**RE: Sawmill Market
1909 Bellamah NW
Grading and Drainage Plan
Engineer's Stamp Date: 7/11/18
Hydrology File: J13D017A**

Based on the submittal received 07/11/2018, the Grading and Drainage Plan **is not** approved for Building Permit or SO-19 Permit. The following comments need to be addressed for approval of the above referenced project:

A1 EROSION AND SEDIMENT CONTROL PLAN
1" = 20'-0"

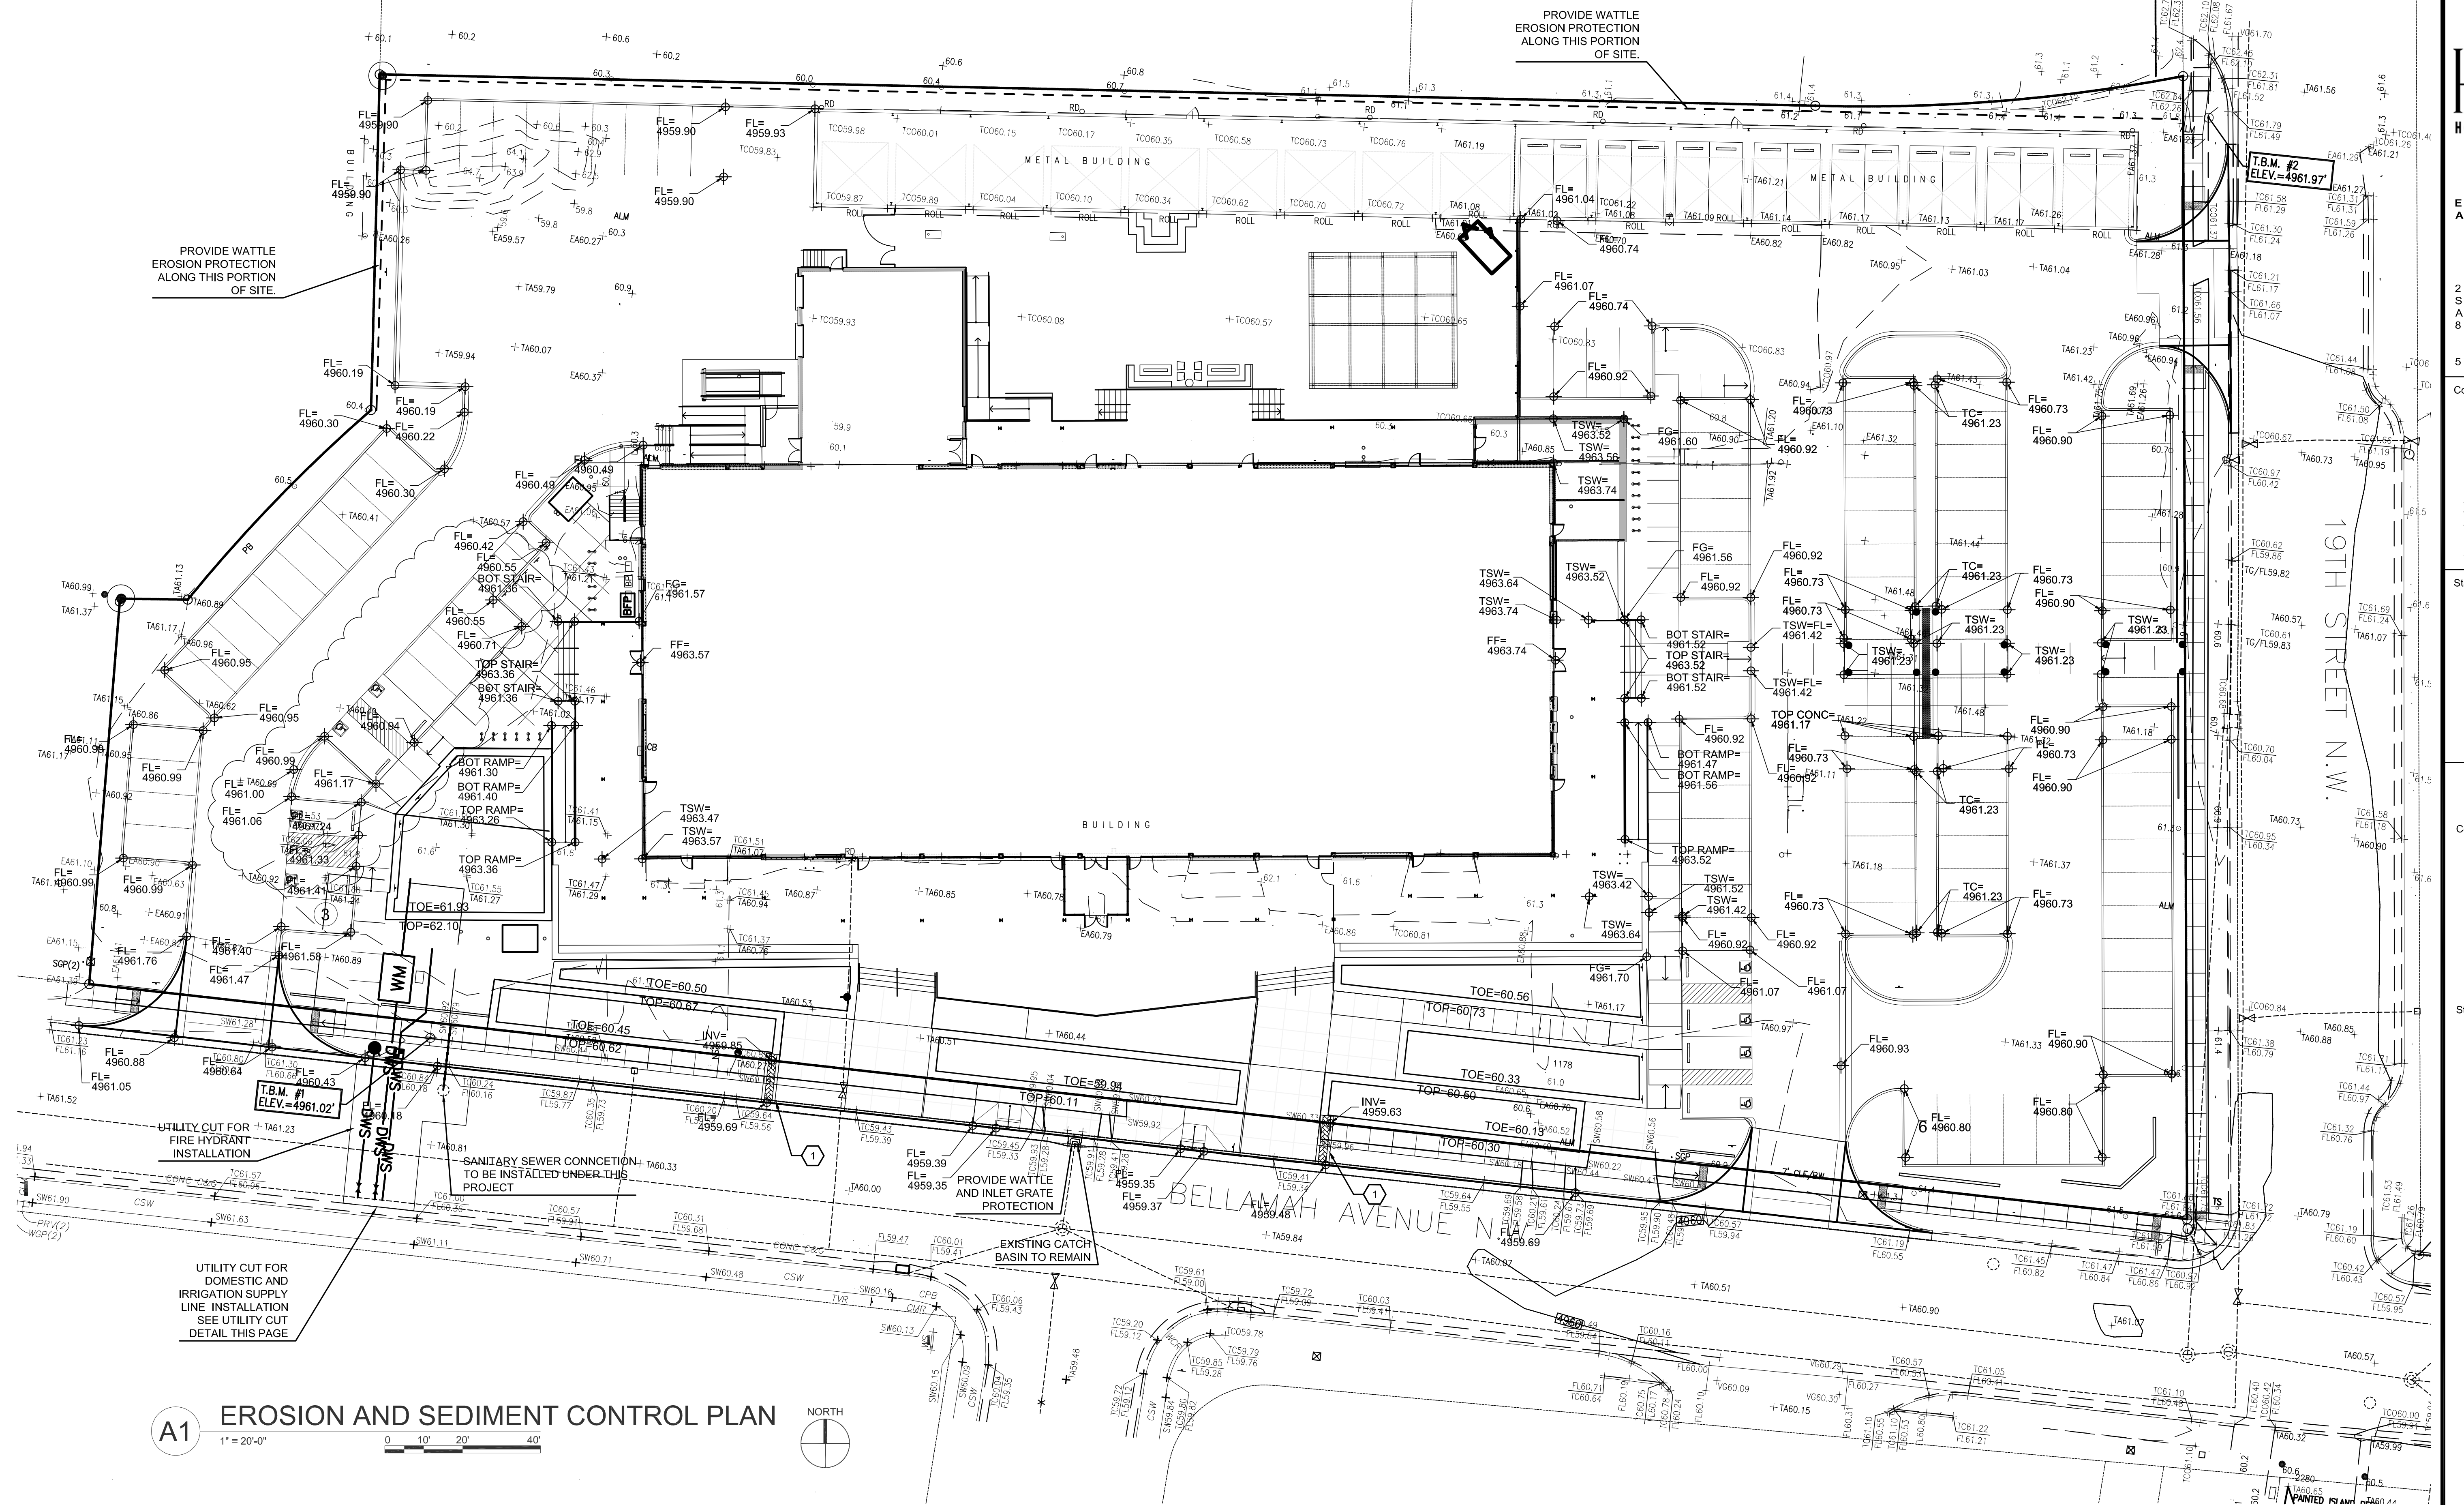
6. This project requires an ESC Plan, submitted to the Stormwater Quality Engineer (Curtis Cherne PE, ccherne@cabq.gov or 924-3420).
